DECISION DELEGATED TO DEVELOPMENT MANAGER

Application No: H17-0149-19 **Applicant:** Mr & Mrs Needham
Proposal: Erection of 5 detached dwellings (Outline Approval H17-0563-16)
Location: Land Adjacent: 72 Station Road Surfleet Spalding
Terminal Date: 5th April 2019

PLOT 2

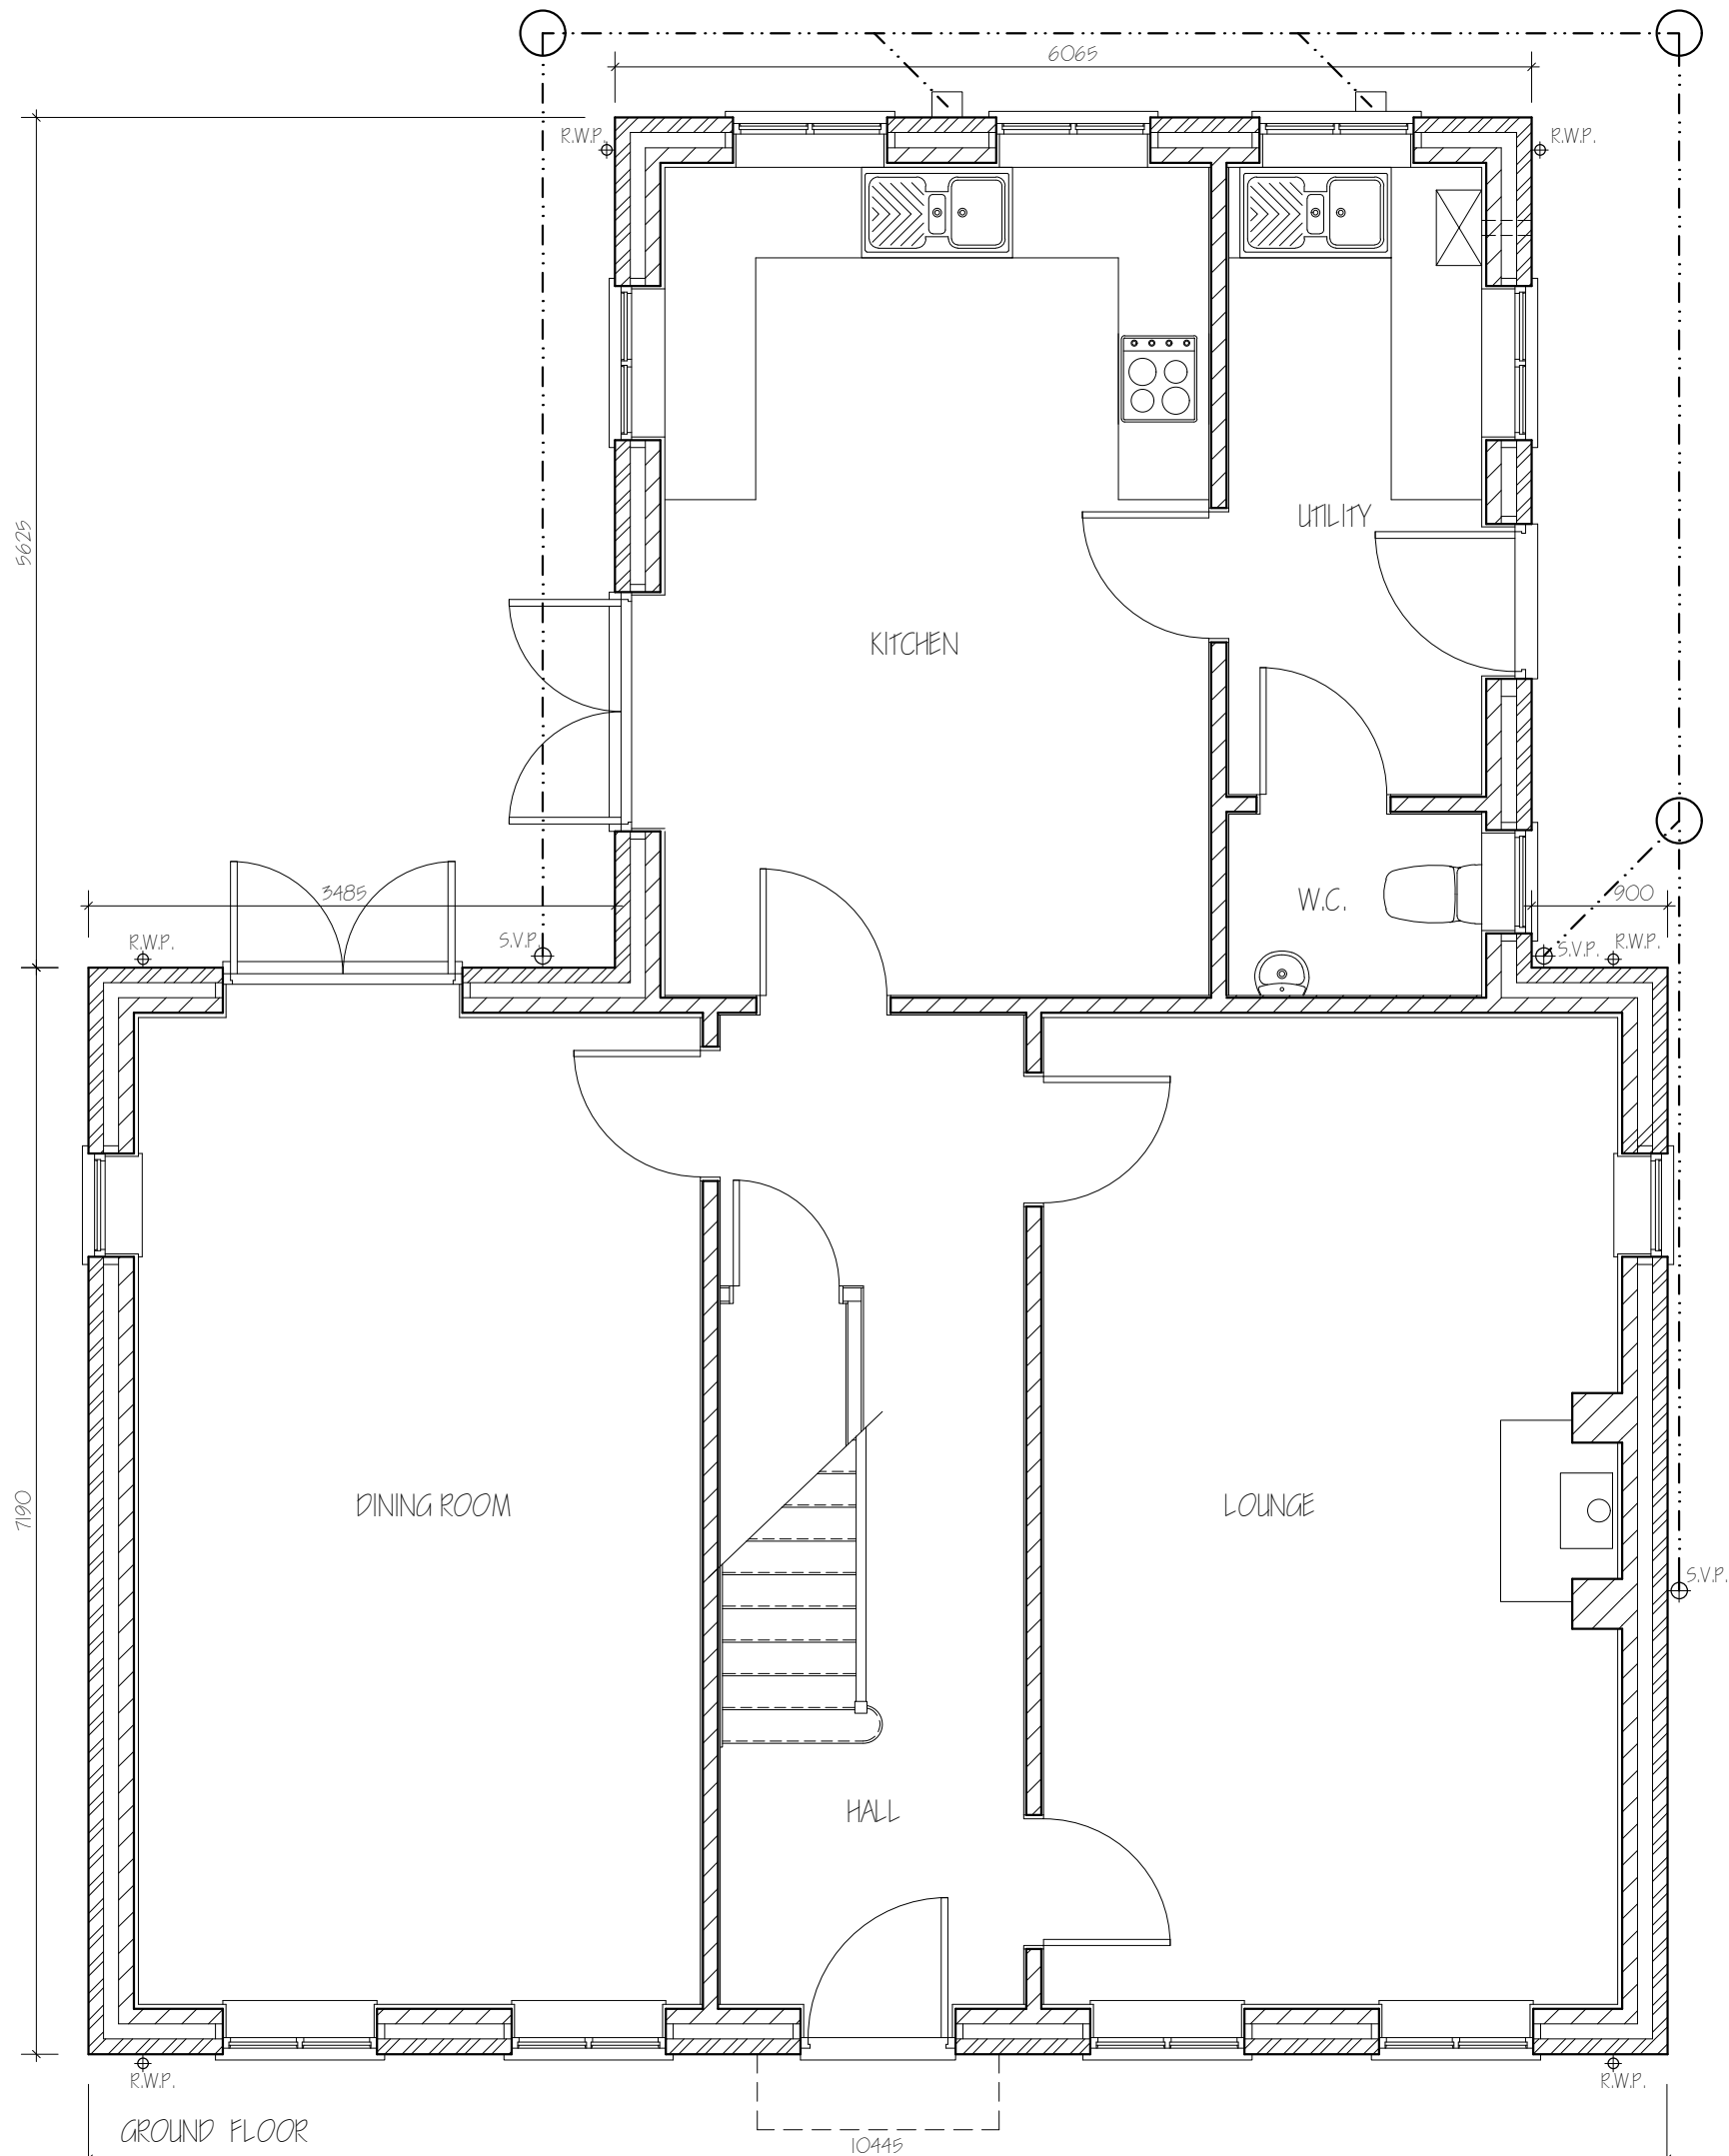
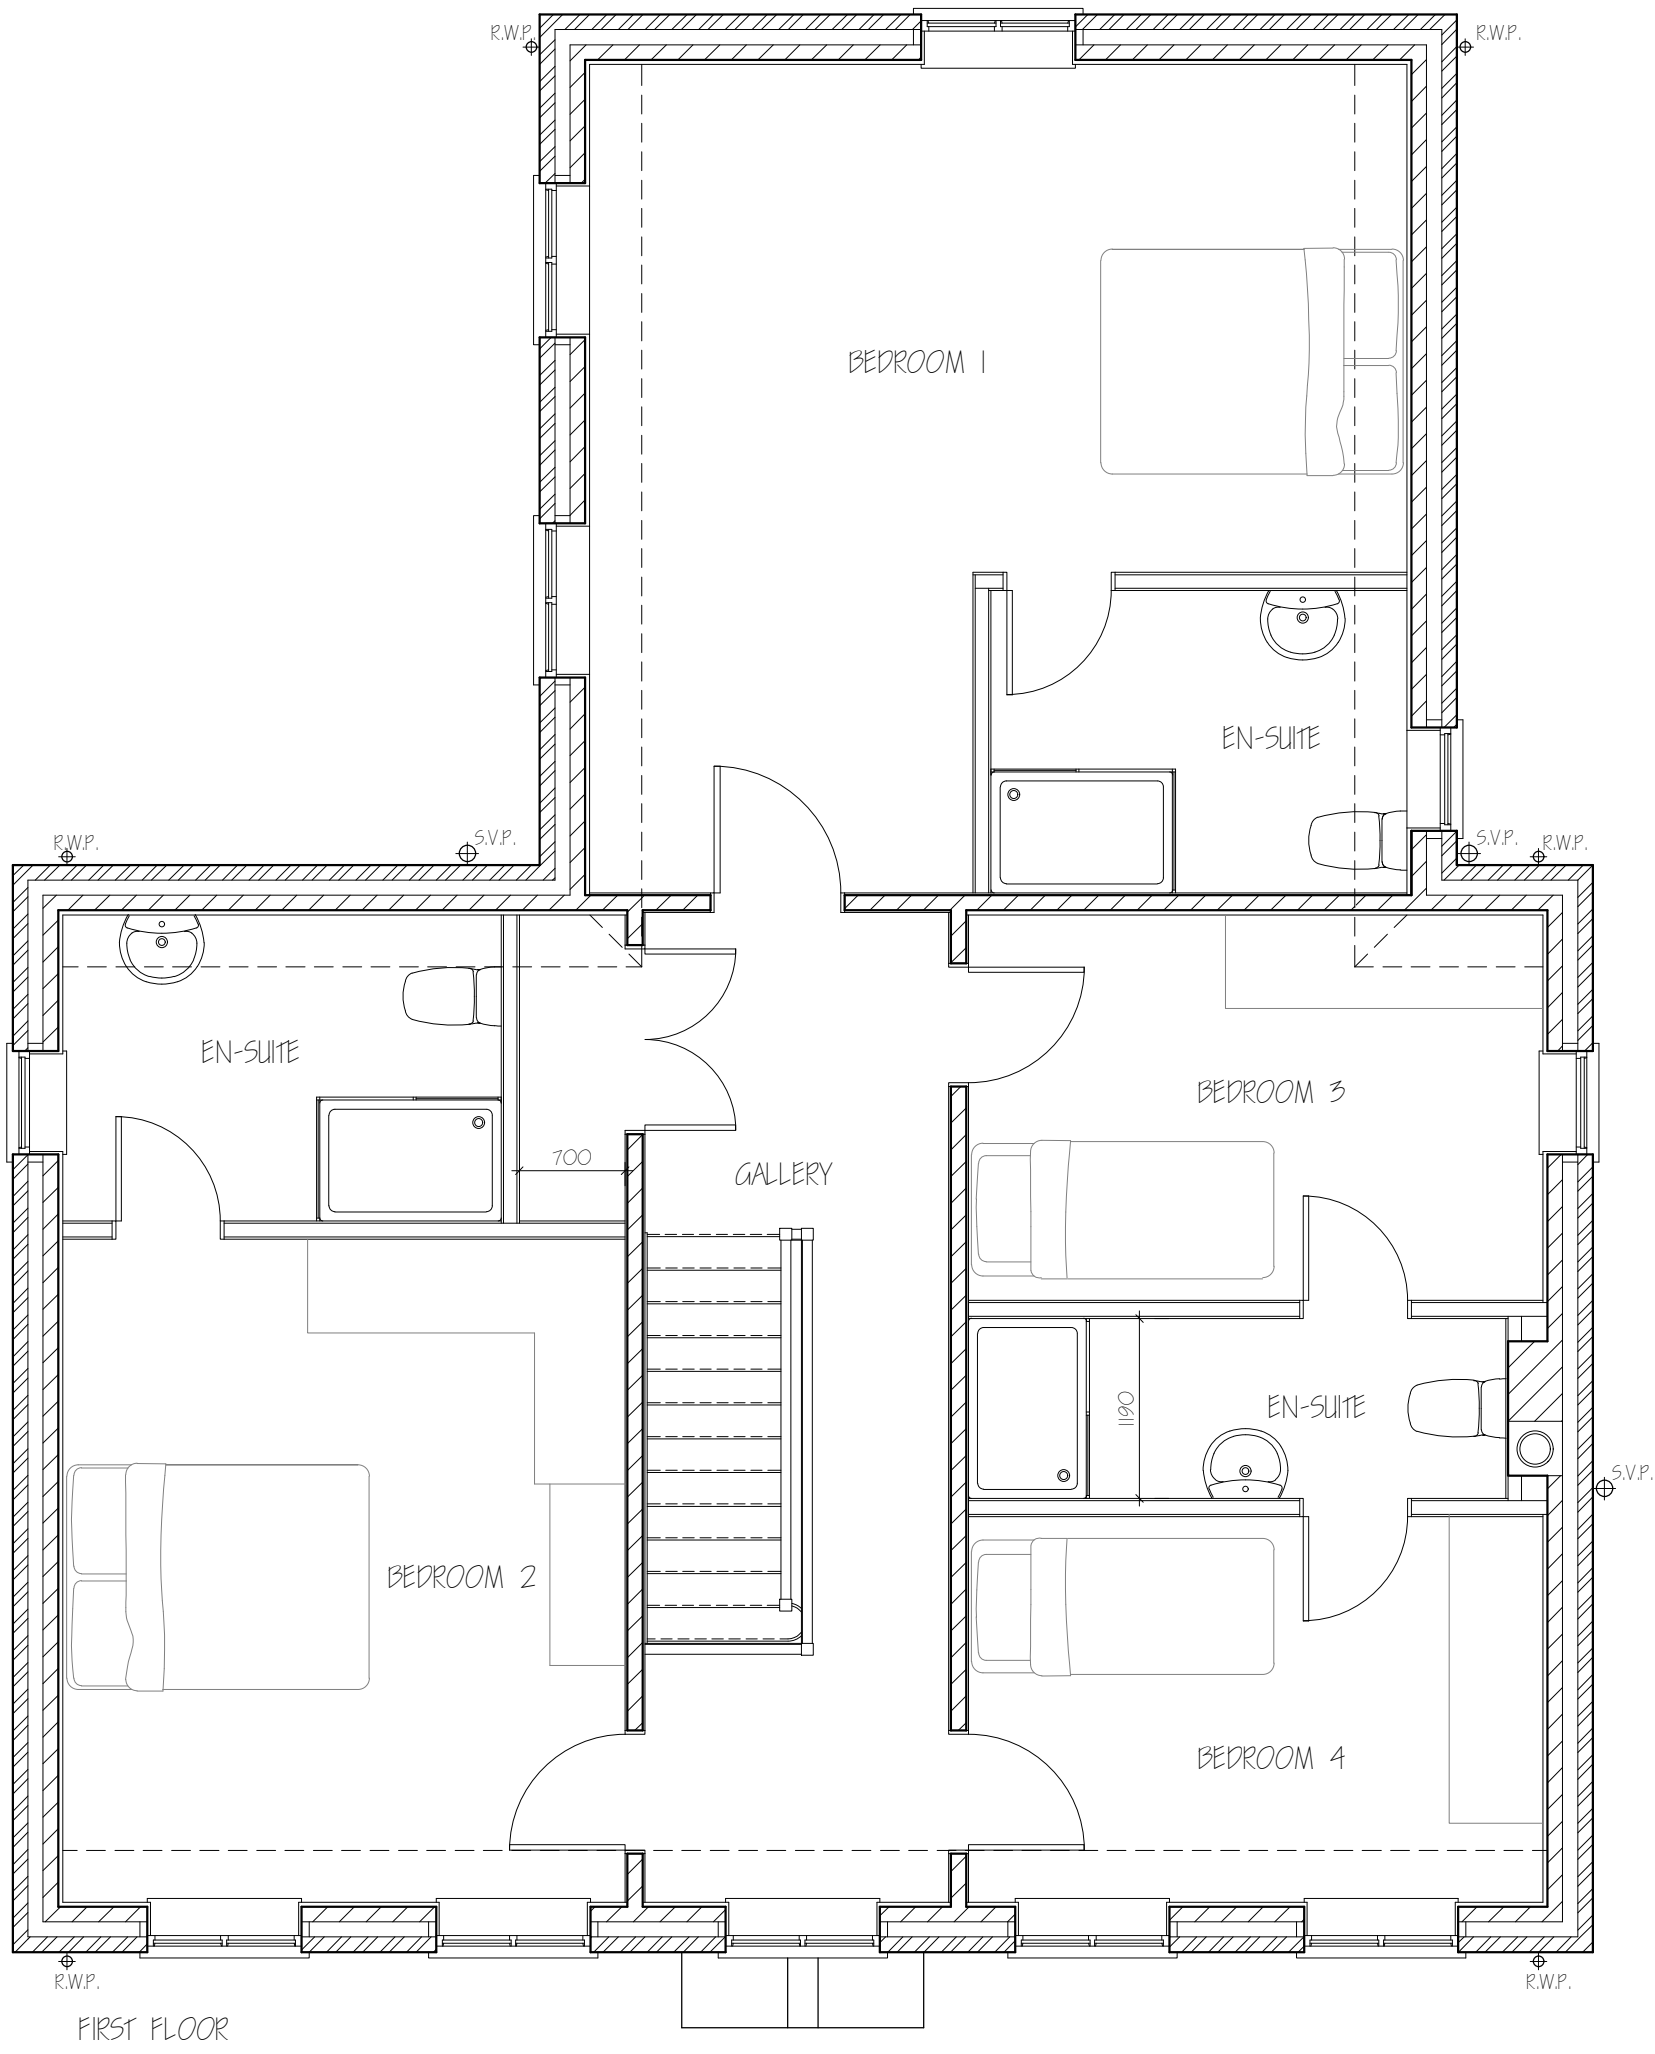
There are no side facing first floor windows on plots 1 or 2 so there would be no issues of overlooking between these and the existing dwellings adjacent. Furthermore, the proposed dwellings have been designed in such a way as to ensure that overlooking is not an issue.
